Re: Falcon Marketplace Preliminary Plan (SP-17-001) Response 4

Please accept this response letter to your review comments dated July 7, 2017.

Preliminary Drainage Report (PDR) / Drainage Plans

C7.1

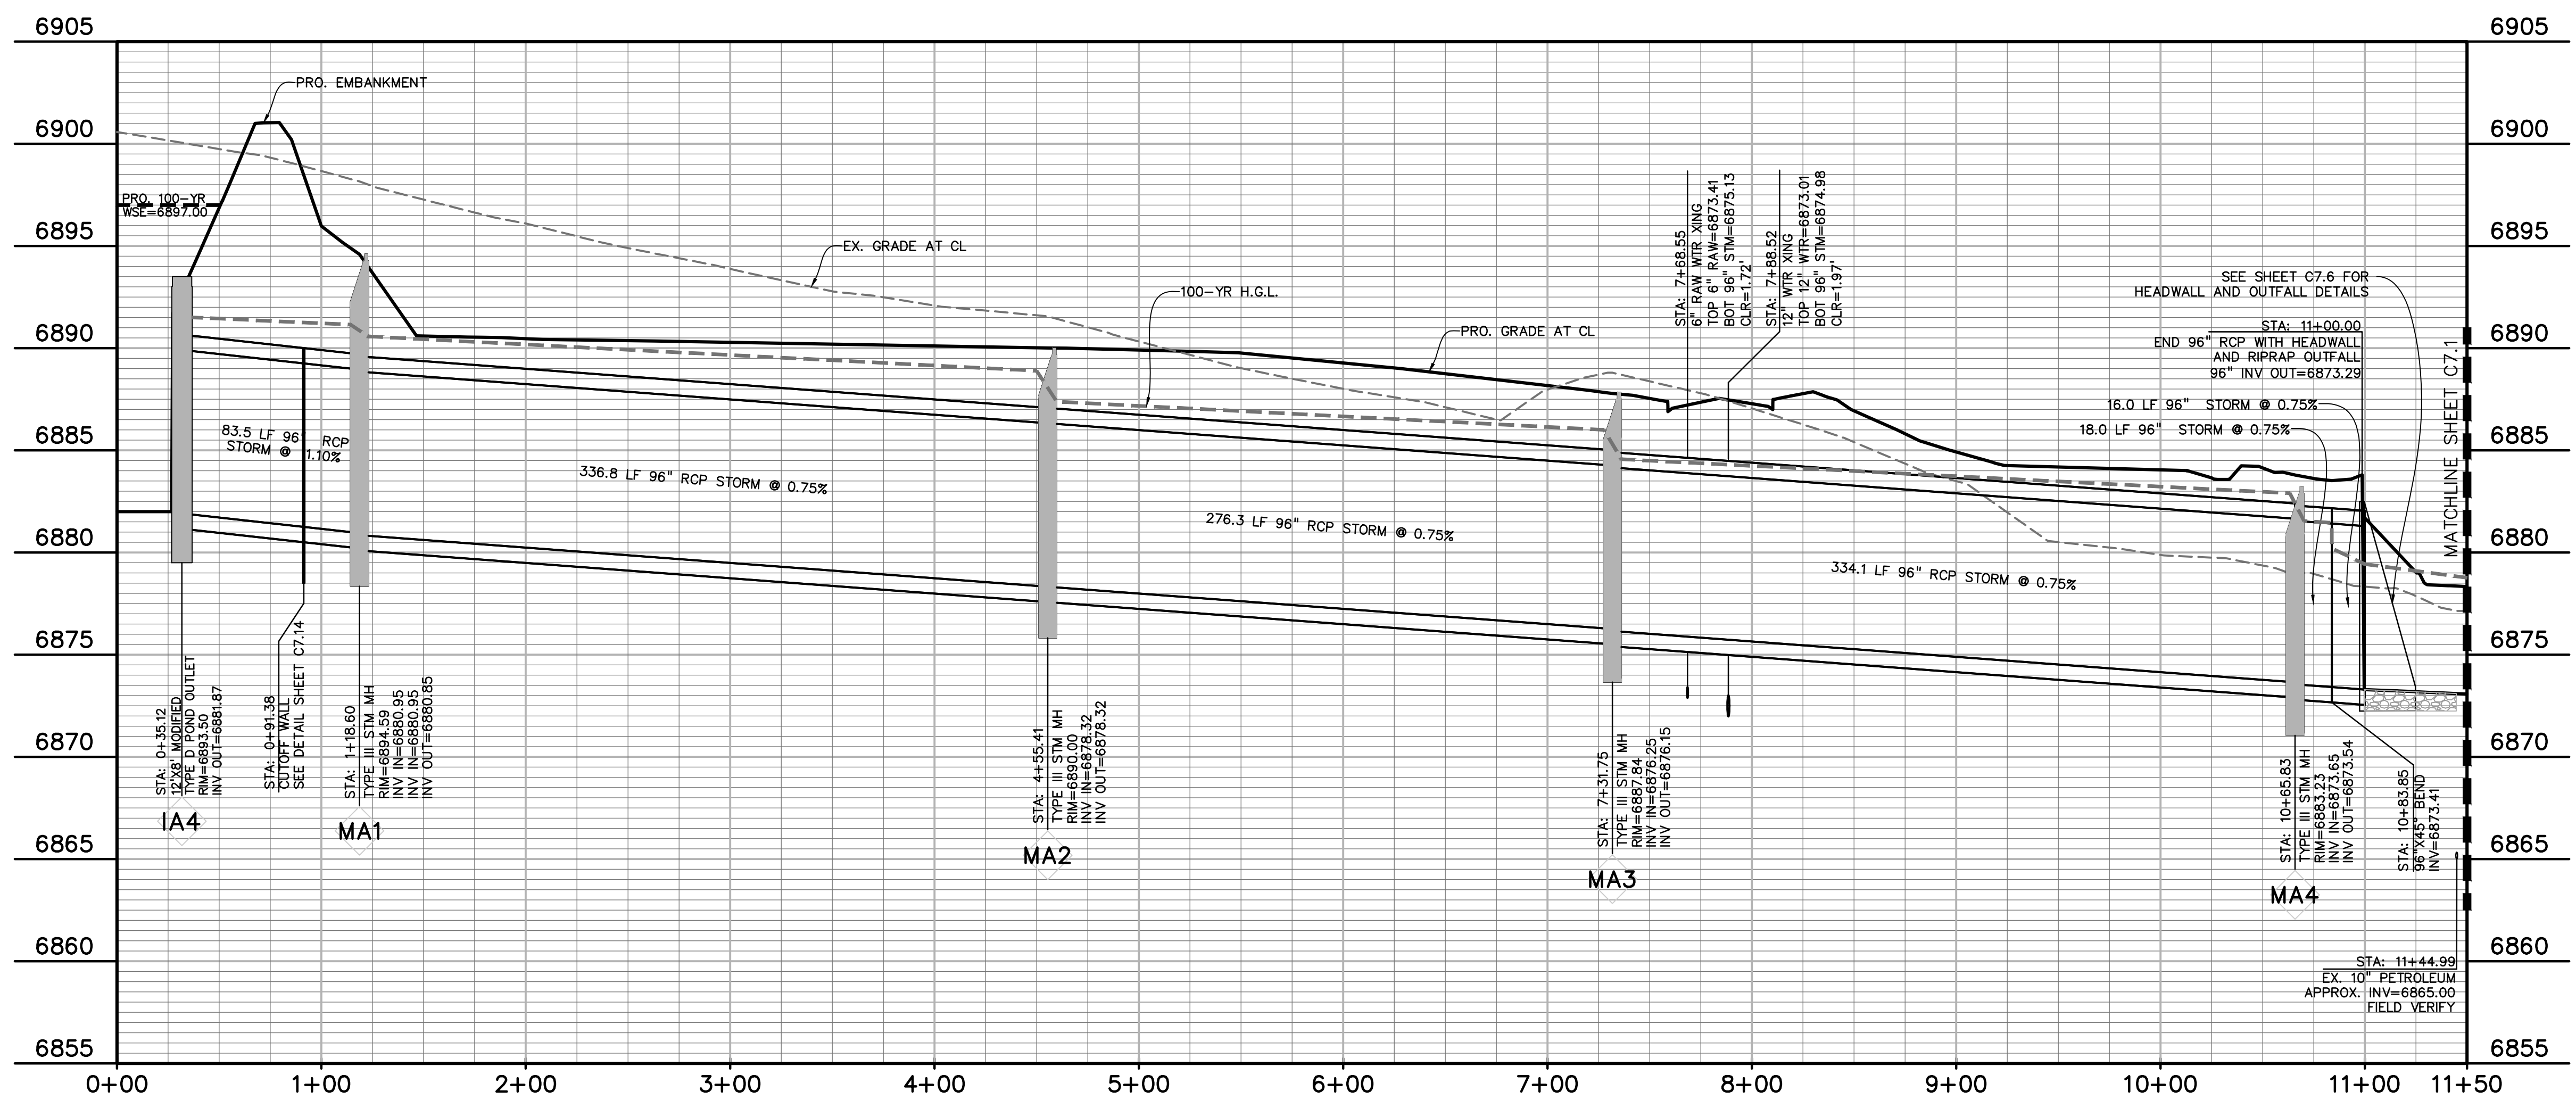
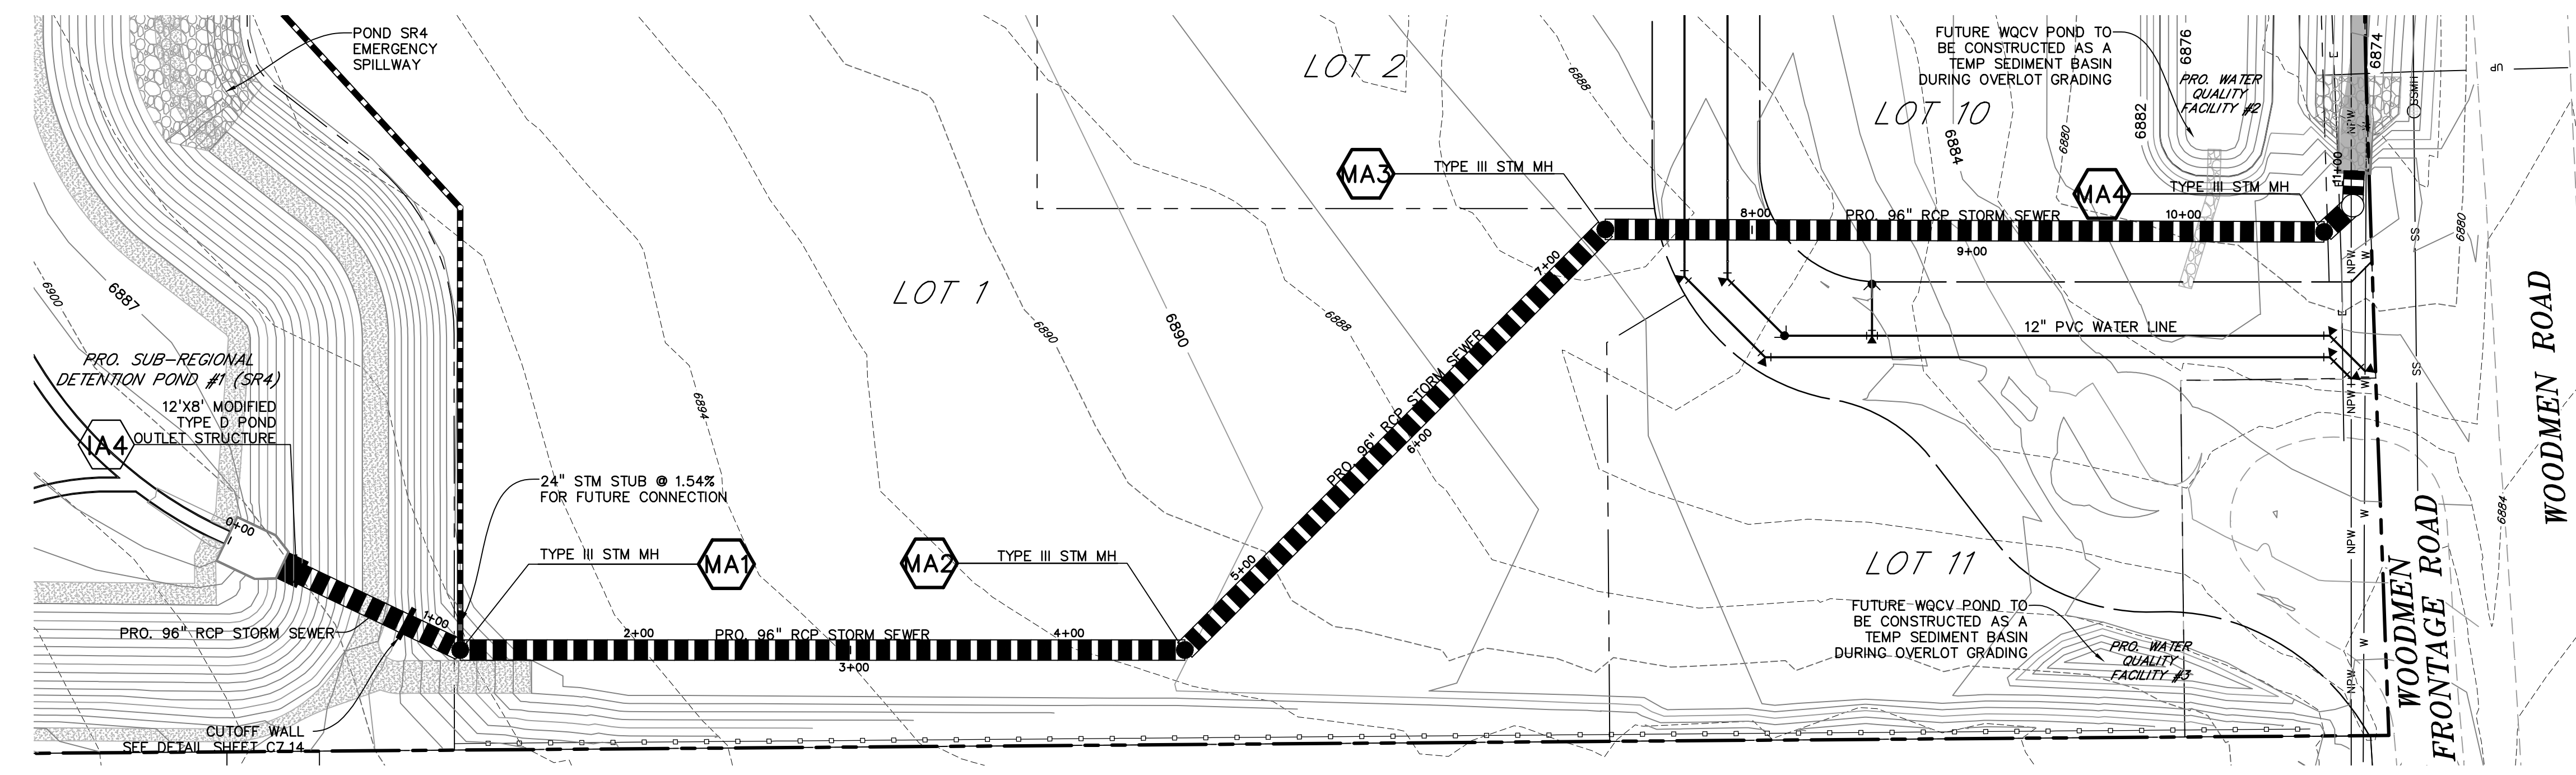
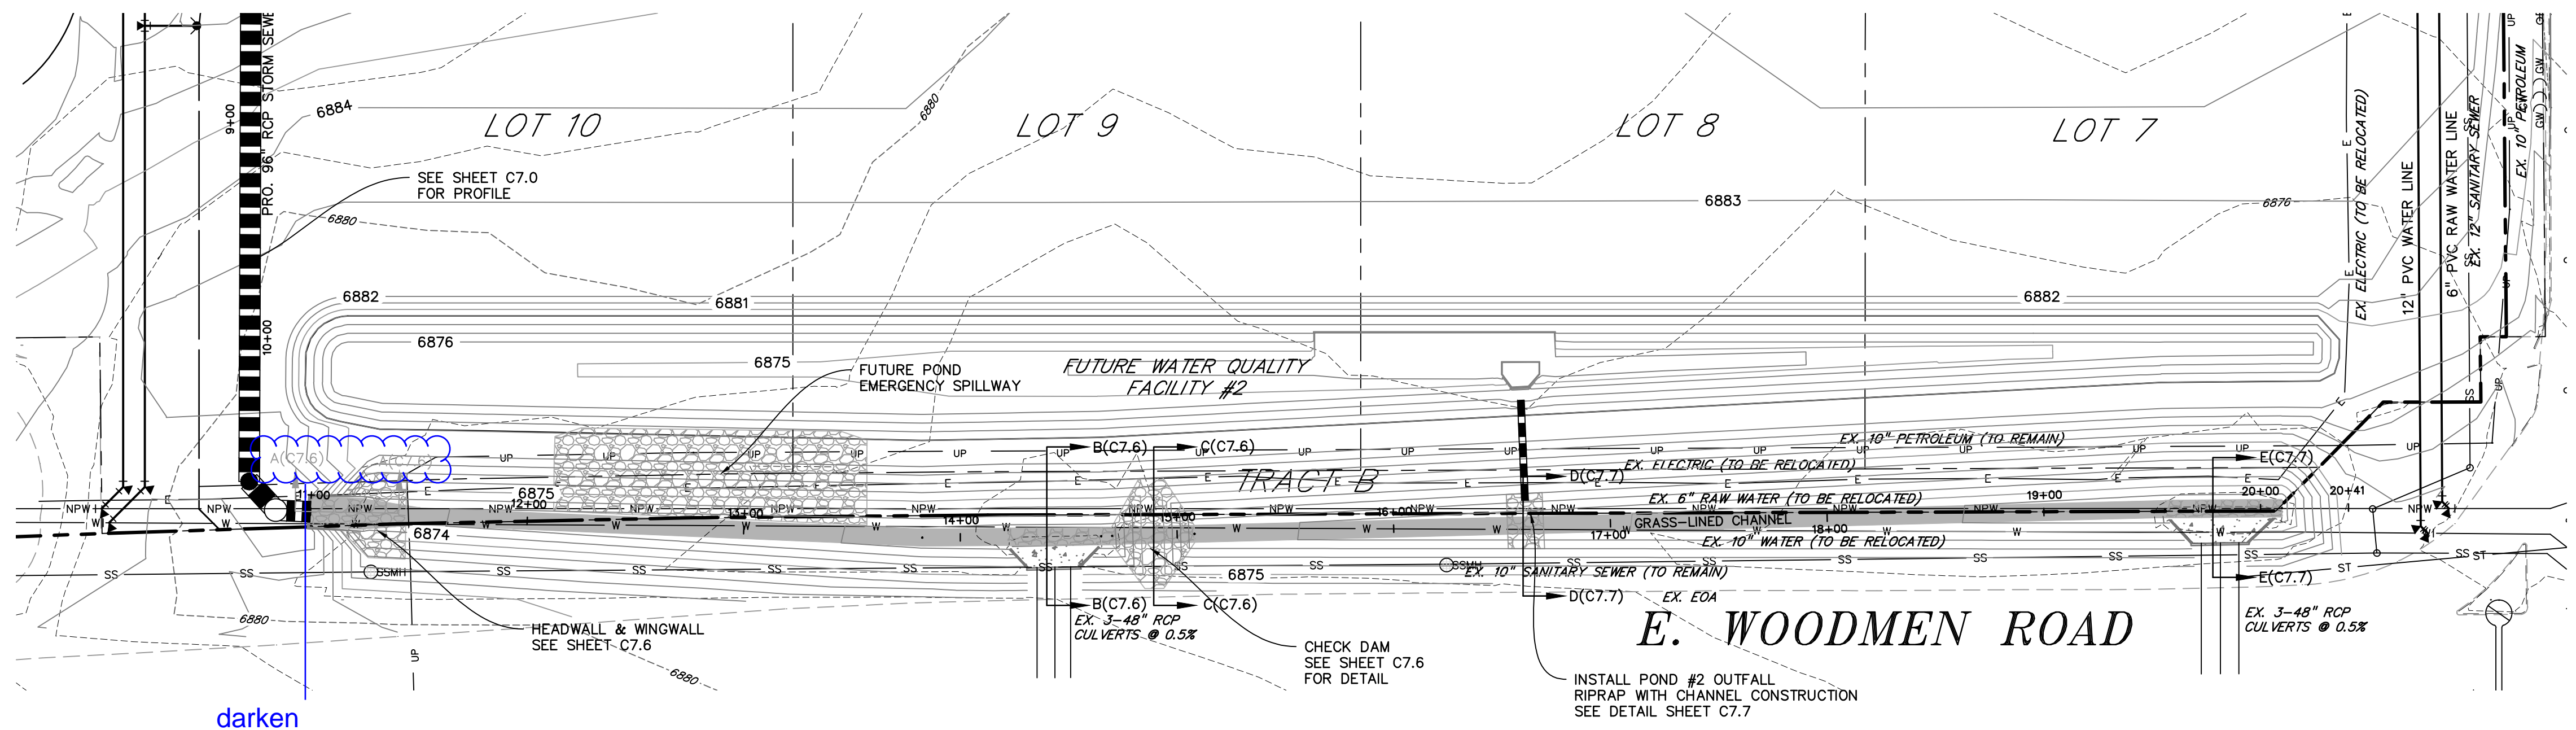
- 2. Include utility locations on all plans and cross-sections. Partially resolved; show or note locations of non-potable water and electric on the cross-sections of the construction drawings per the comment response. 2/17: *Comment remains.* 5/30: *Comment remains.* 7/6: *Comment remains.* **Cross sections updated to show all utility crossings.**

SUB-REGIONAL POND #1 (SR4)
 PROJECT NO. 20988-00CSCV
 DRAWING NO.

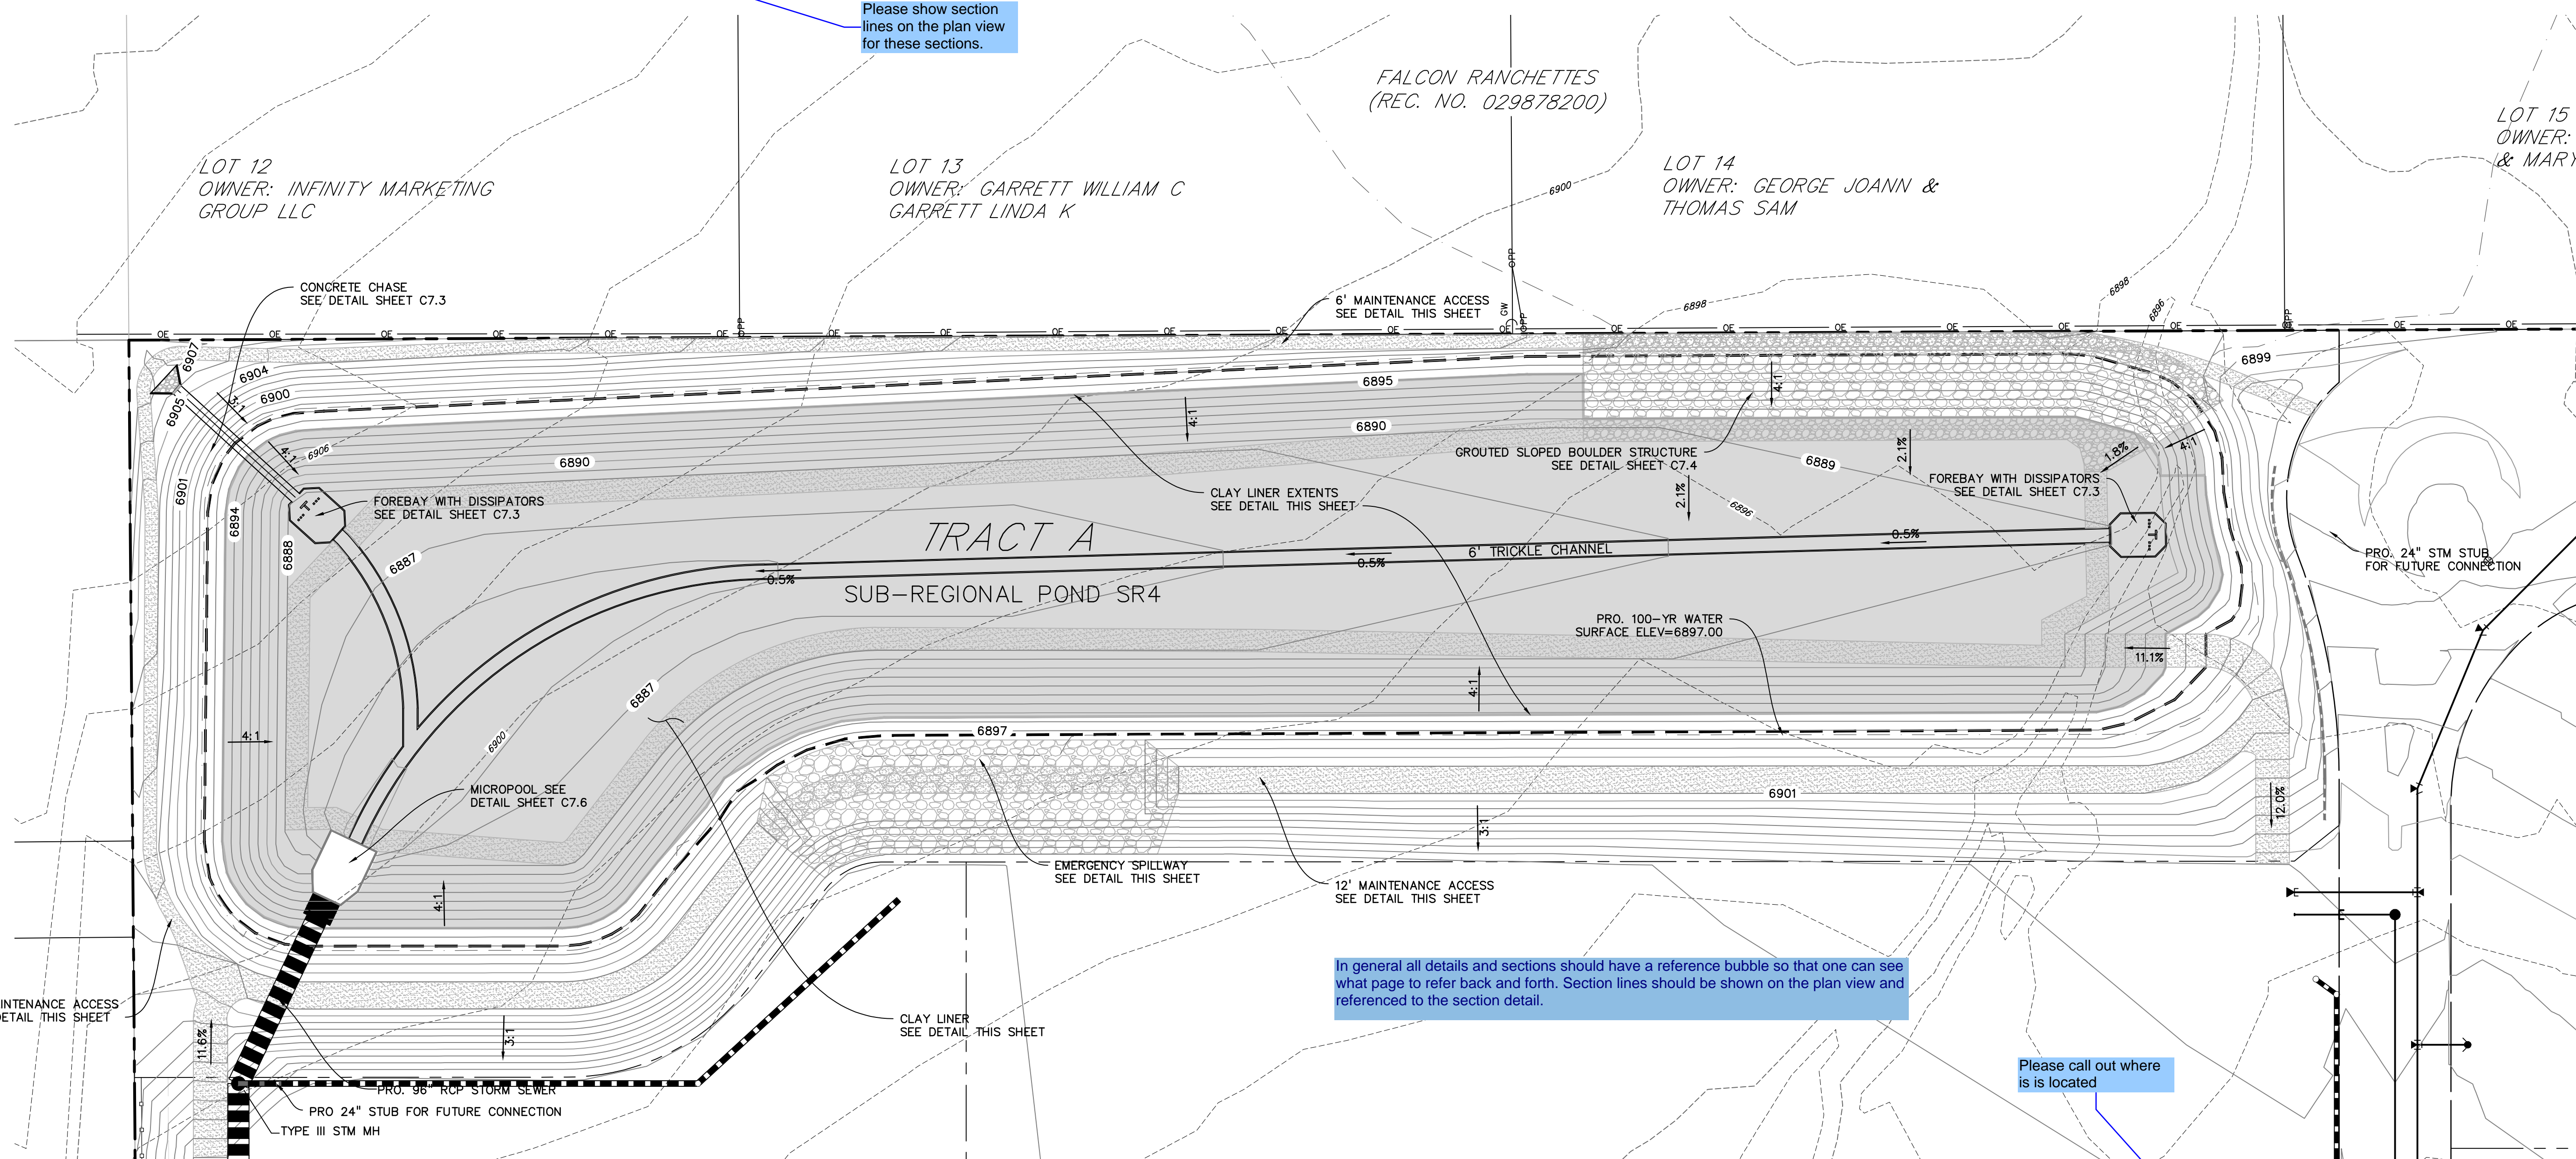
- b. Consider replacing the proposed area drain and pipe at the northwest corner with a swale along the north property line to the proposed rundown. Maintenance access appears likely to be difficult as proposed and the geotech. study recommends "properly designed drainage swale" at the tops of excavation slopes. Partially resolved; stabilization of and maintenance access to the 3:1 (and steeper?) excavated slope along the north side of Pond SR4 will need to be further addressed with the final pond design. *(If the extent of overlot grading includes the slopes, this needs to be addressed with overlot grading.) Comment remains; access road design, offsite grading (requiring easements) sheet flow locations and rundowns and the concrete rundown need additional detail to ensure adequate access and functioning. Plan sheets amended per redlines. Maintenance/stabilization road added at the bottom of the pond.*

- b. Show and label all proposed maintenance access roads and easements on the Developed Conditions Plan. Partially resolved; see GEC redlines regarding this. Provide stabilized access roads along the west and north sides of the pond. *See additional redlines; due to the rundown along the north side of the pond, pond bottom stabilization is required which could be incorporated into an access road design through that area. Comment remains. Stabilization of the pond bottom has been incorporated into the design.*
